## ATTACHMENT 1 – Department’s Response to Submission review comments

In order to finalise the Department’s assessment, additional information is required including but not limited to the following:

Figure 2.1. Swept paths for heavy vehicles accessing the site at 14- 16 Kiora Crescent, Yennora. NSW Surveys PTY LTD, 8/11/19.

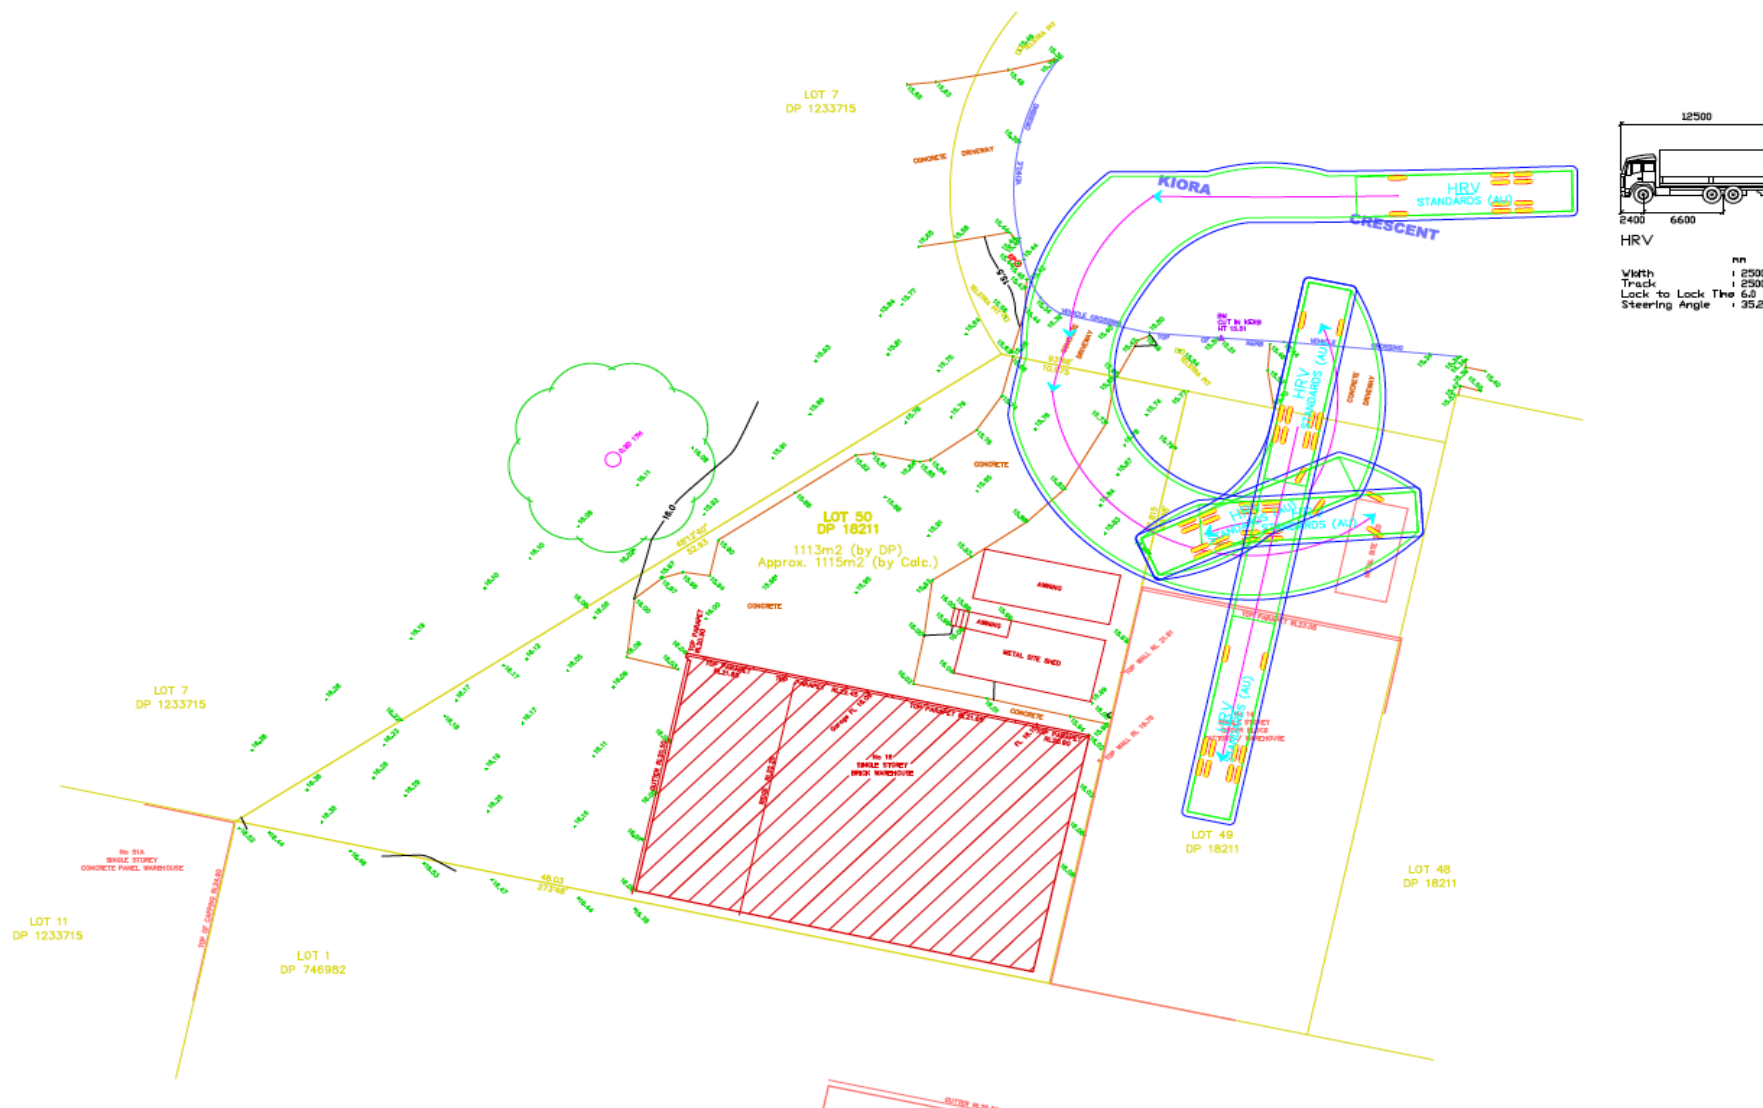
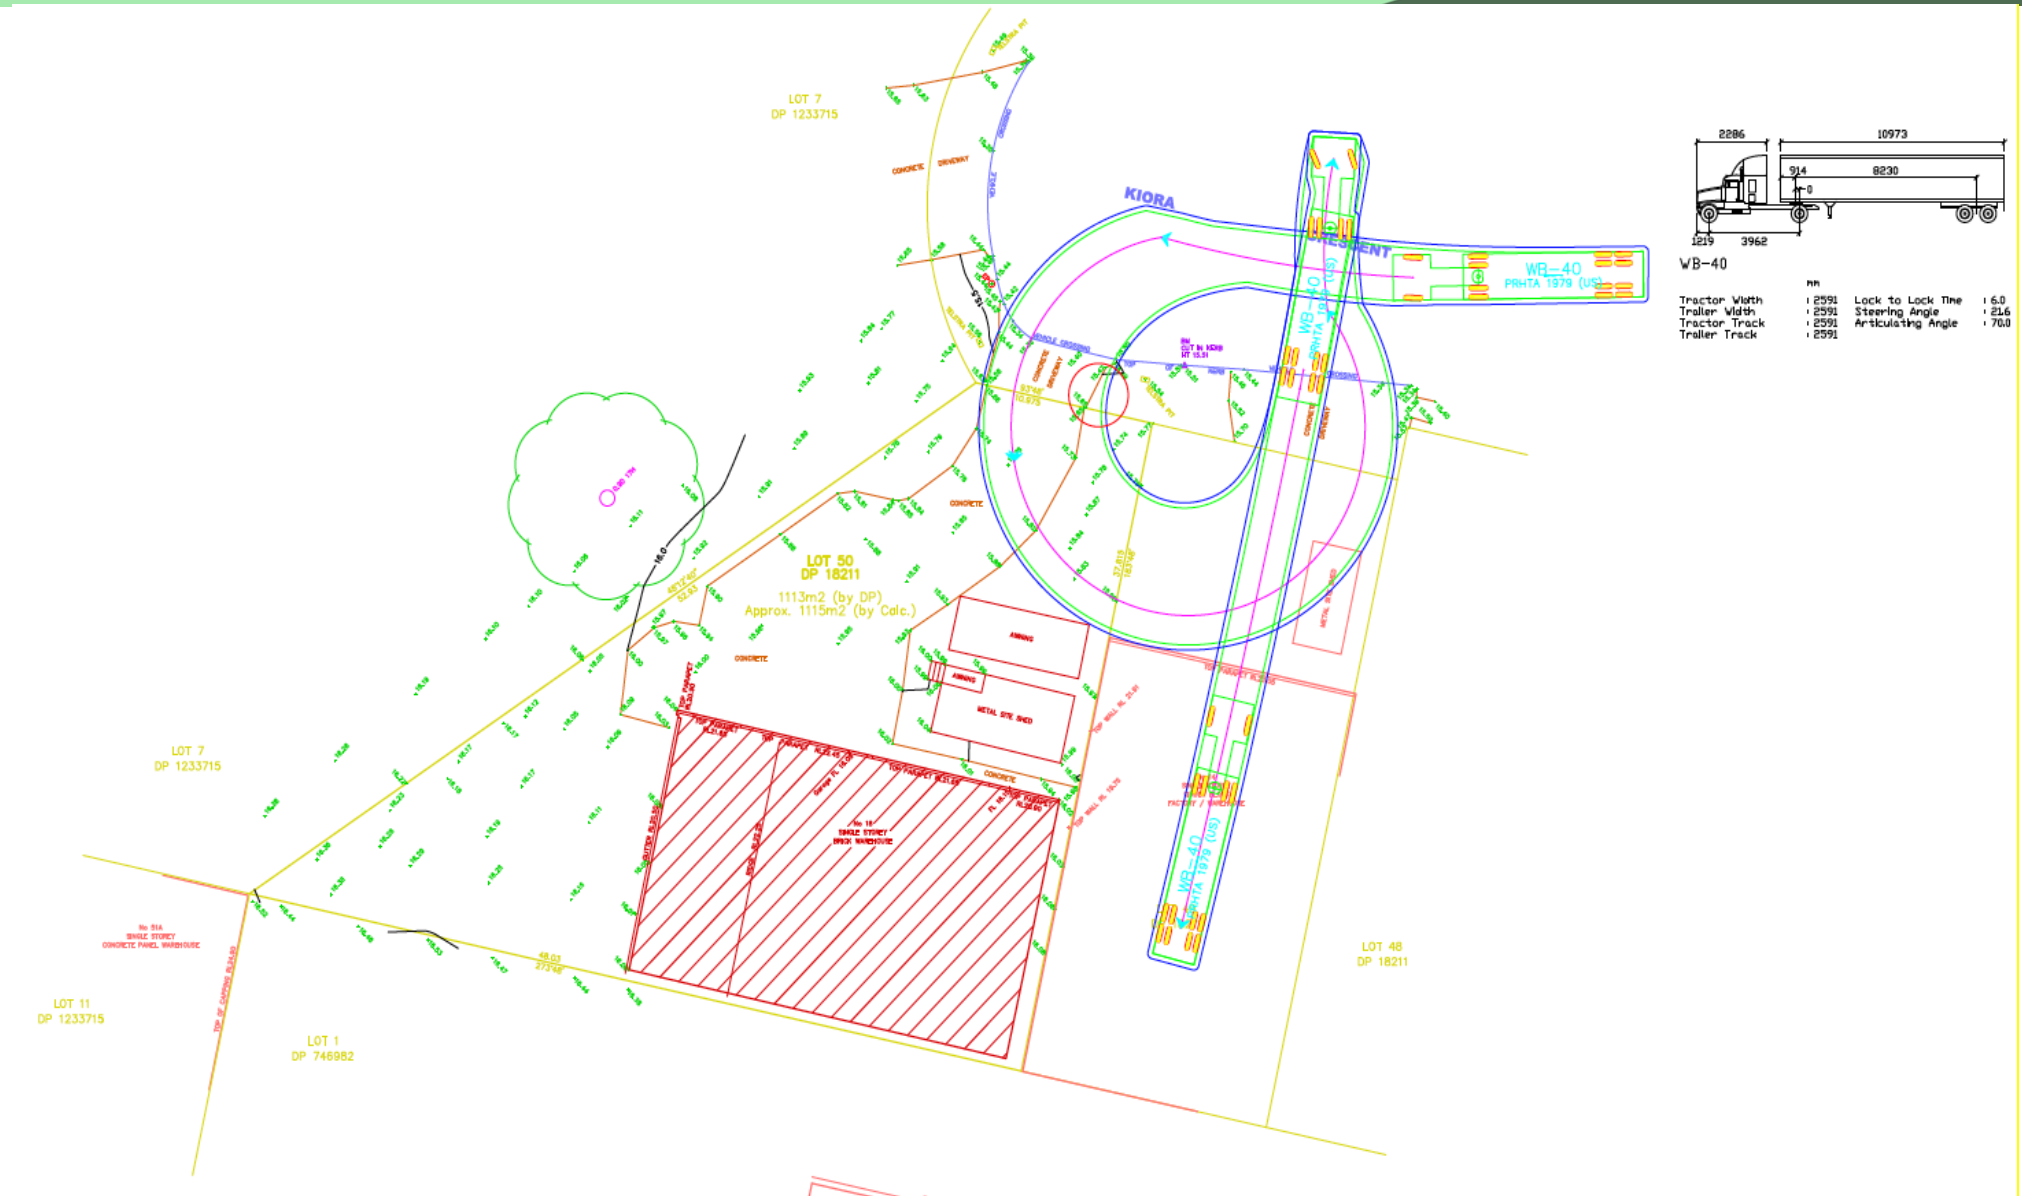
- The vehicle and trucks registration provided in Attachment 8 of the revised EIS lists a site vehicle which is 11.5 metres (m) in length, however swept paths provided have only been provided for 10 m trucks. For consideration of potential future delivery vehicles and to be consistent with Australian Standards, swept paths should be provided for 12.5 m trucks. Please update.

- Update the swept path drawing to clearly demonstrate vehicle movements entering and leaving both 14 and 16 Kiara Crescent.
